Application by National Grid Electricity Transmission (NGET) for a Development Consent Order (DCO) for the proposed Norwich to Tilbury Project (Application Reference: EN020027).

Essex County Council (ECC) Norwich to Tilbury Deadline 6 Submission.

Figure 2c: Mitigation Area 114 over Trial Trench Locations

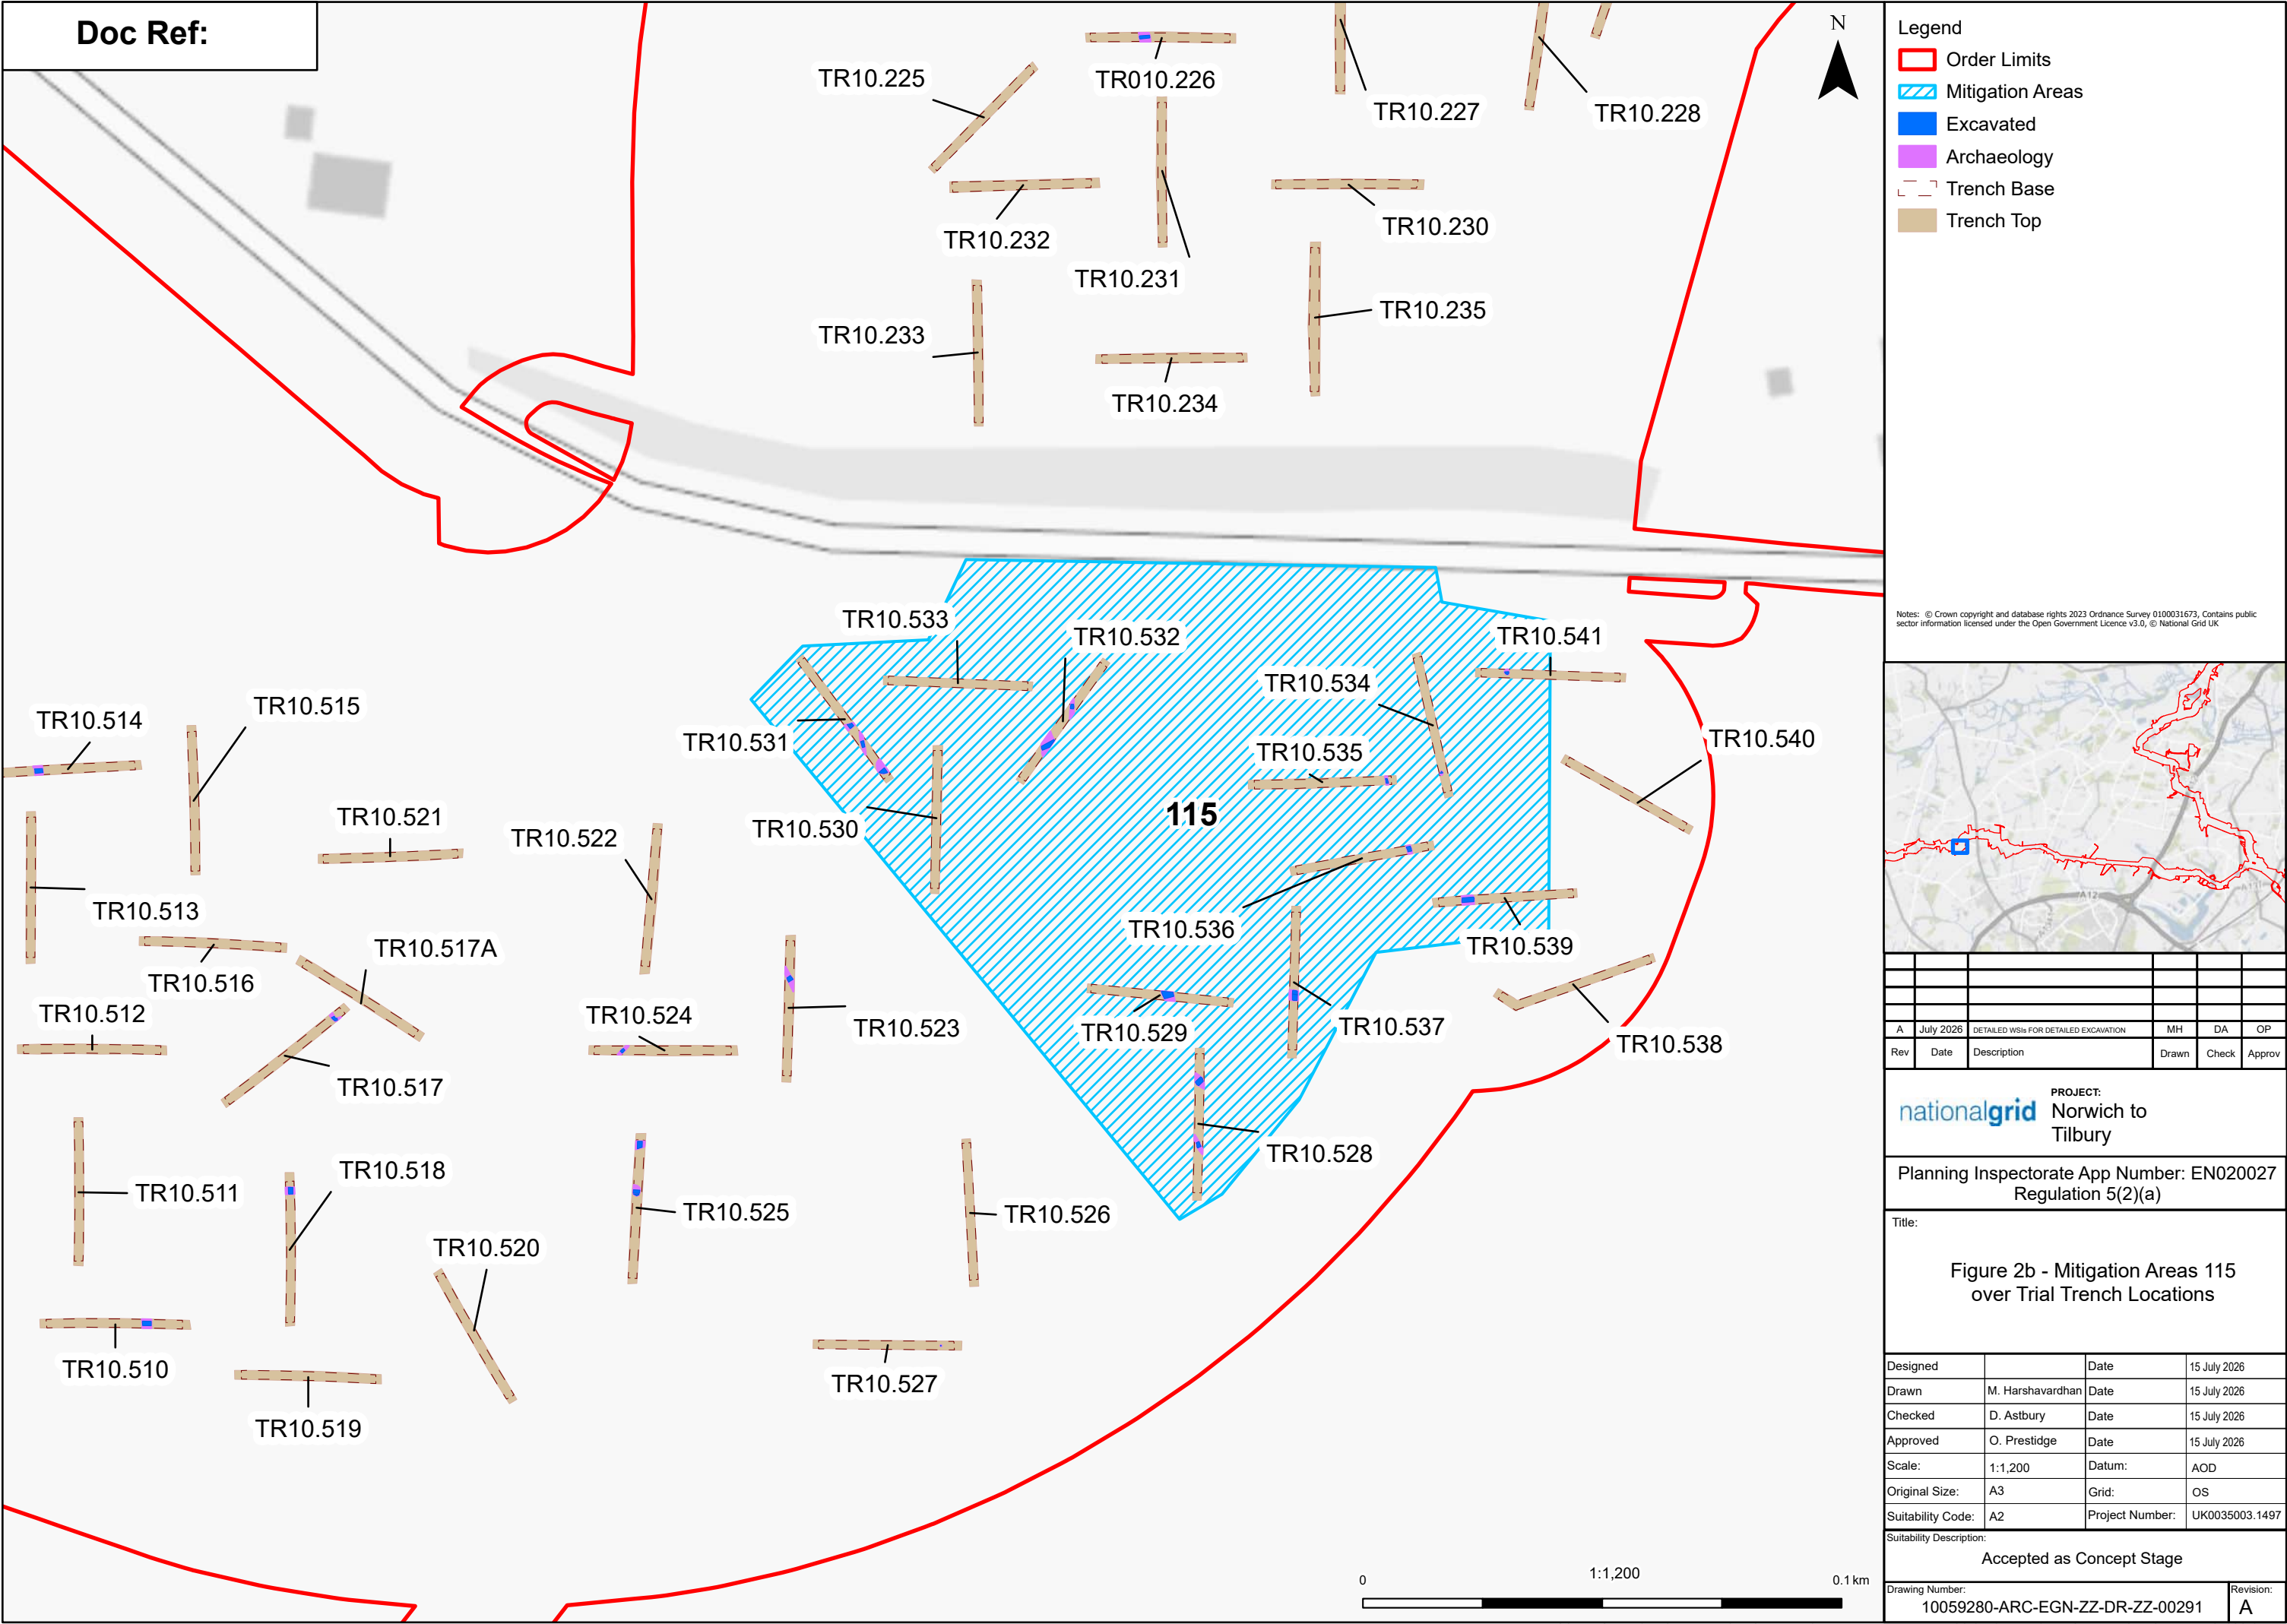
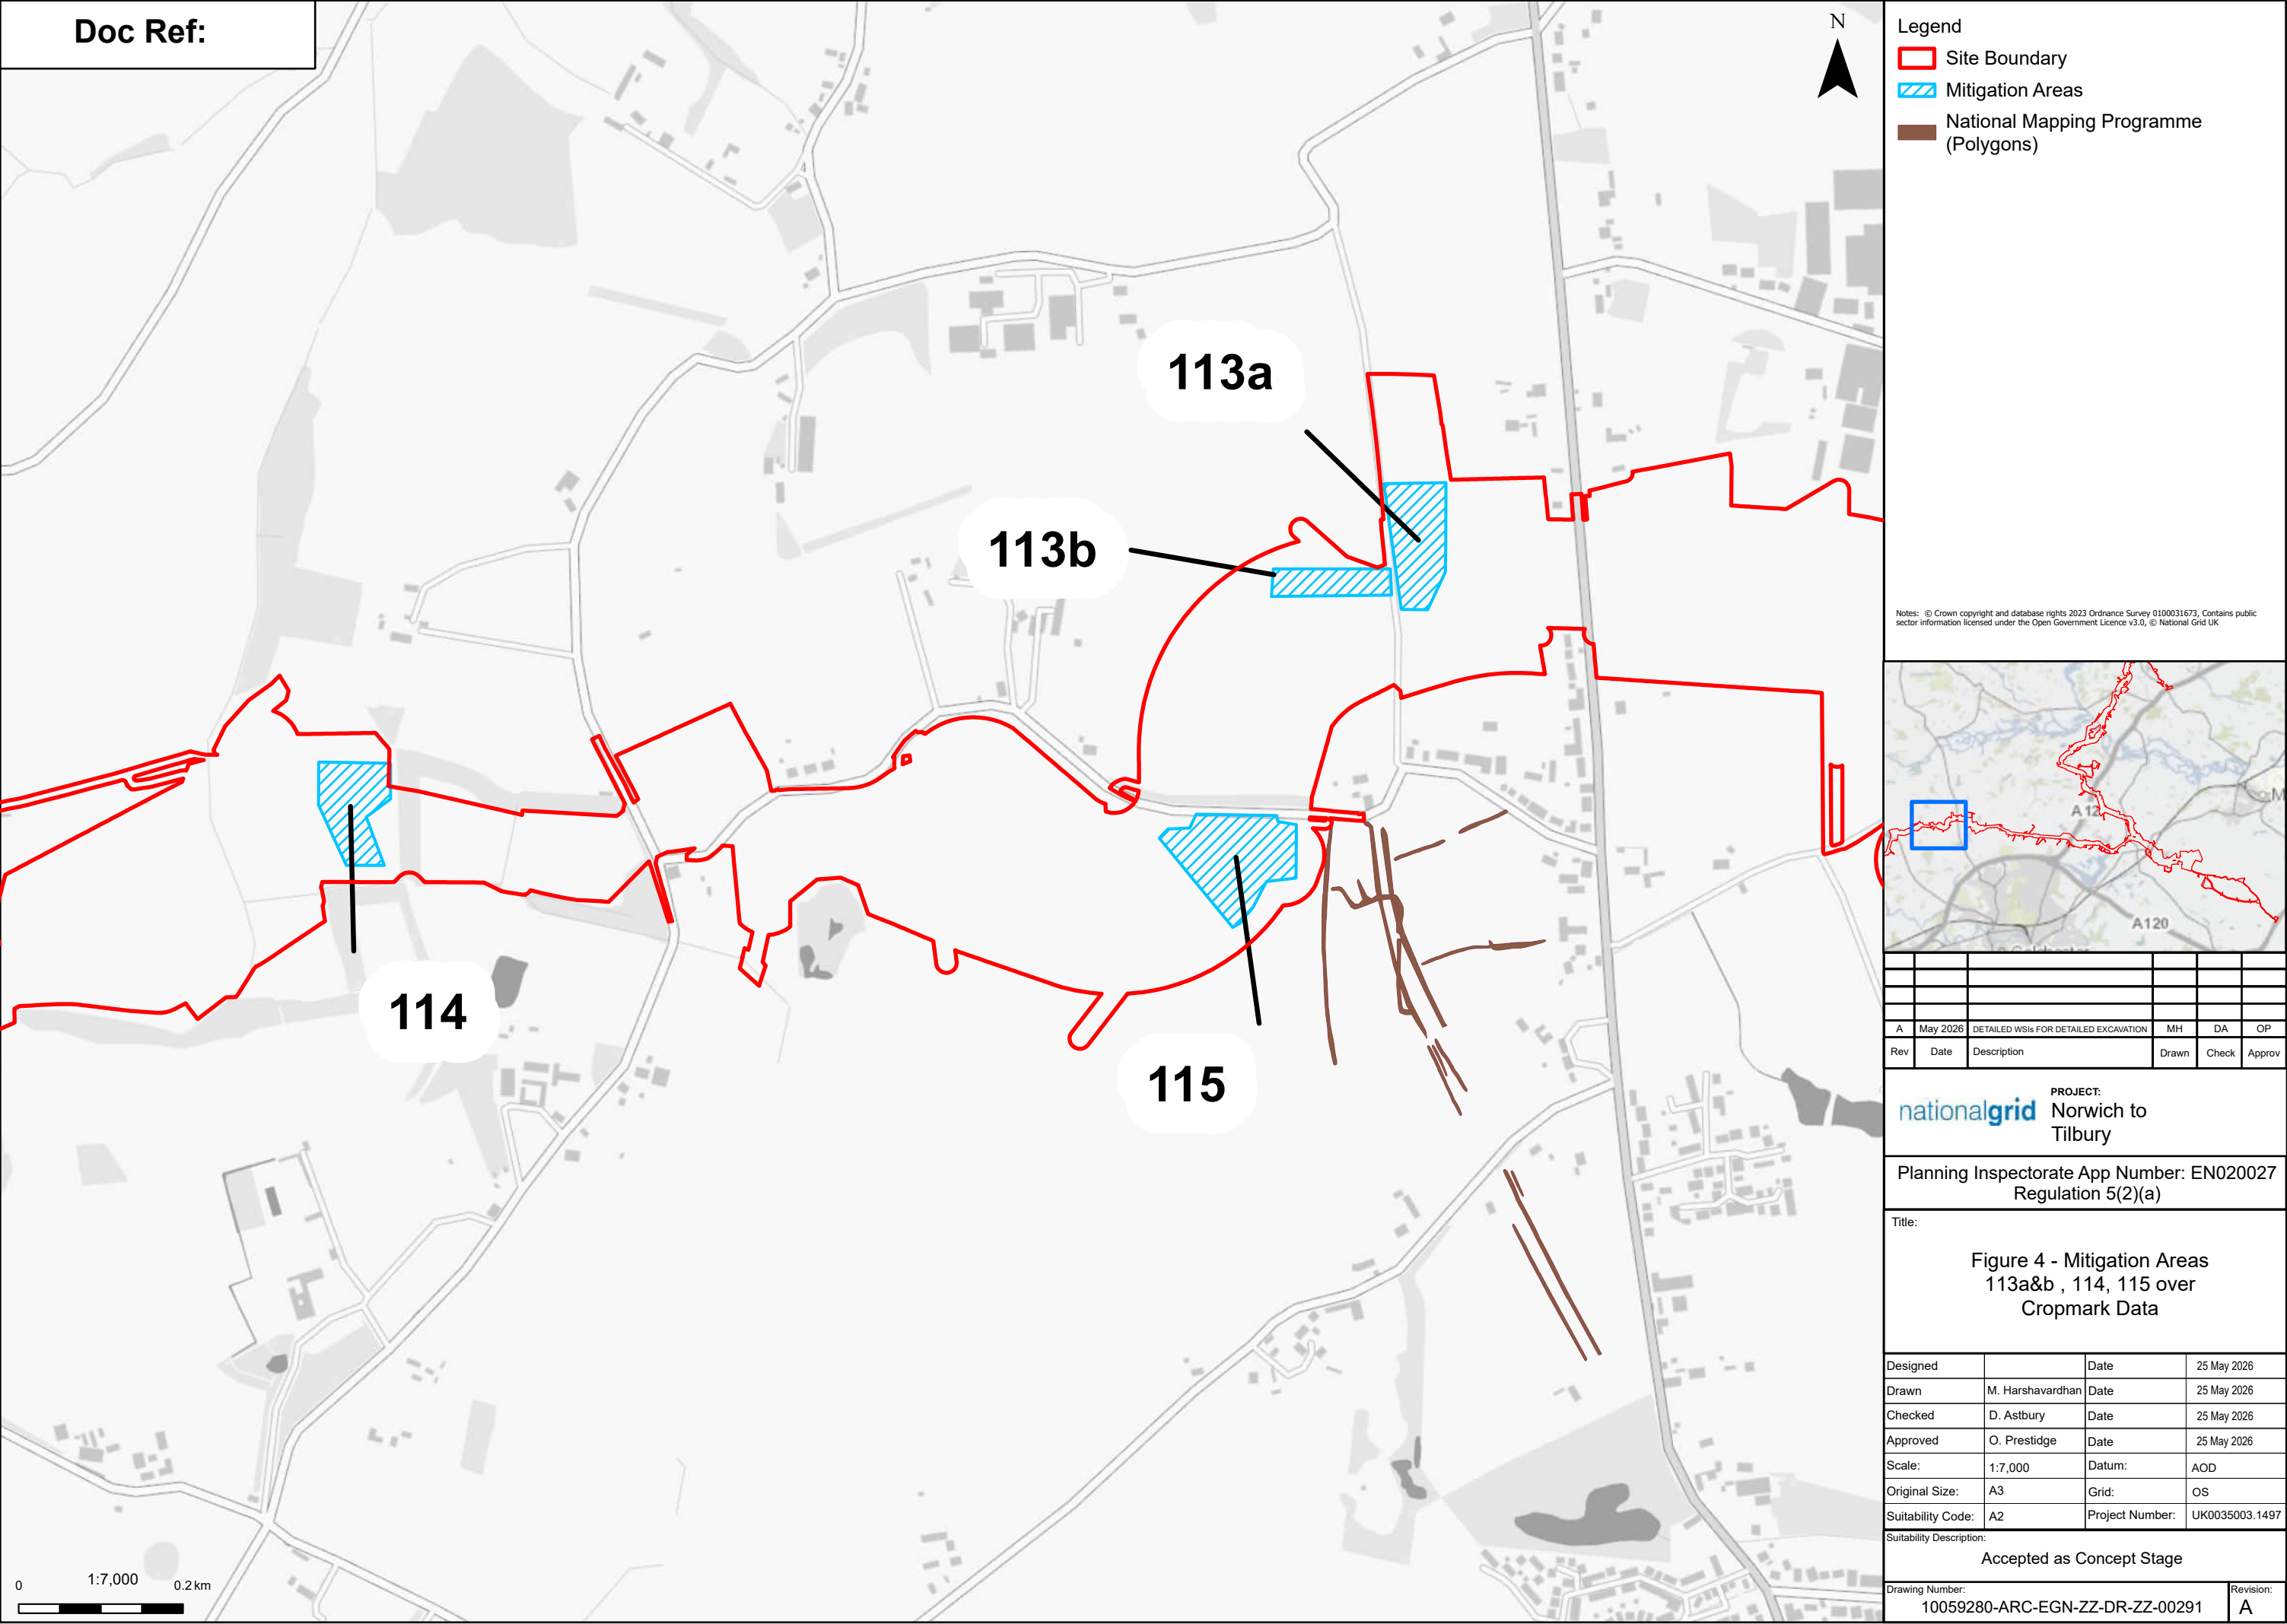
- 8.21 Detailed Written Scheme of Investigation – Mitigation areas 124, 136 (a & b), 137, 138, 141 & 142 Final Issue A (REP5-220)
- 8.22 Detailed Written Scheme of Investigation – Mitigation areas 126, 128 (a, b & c) & 140. Final Issue A (REP5-221)
- 8.23 Detailed Written Scheme of Investigation – Mitigation areas 109, 110, 111, 112 (a & b) & 139. Final Issue A (REP5-222)
- 8.24 Detailed Written Scheme of Investigation – Mitigation areas 113 (a & b), 114 & 115. Final Issue A (REP5-223)

1.32. The documents submitted are not acceptable in their current form, further information has been requested directly to the Applicant to facilitate full consideration of the mitigation proposals. The sites proposed for mitigation have not yet been discussed or approved by the archaeological advisor and there has been limited time since submission to consider these documents. It is considered inadvisable to secure mitigation at this stage of the application due to time constraints.
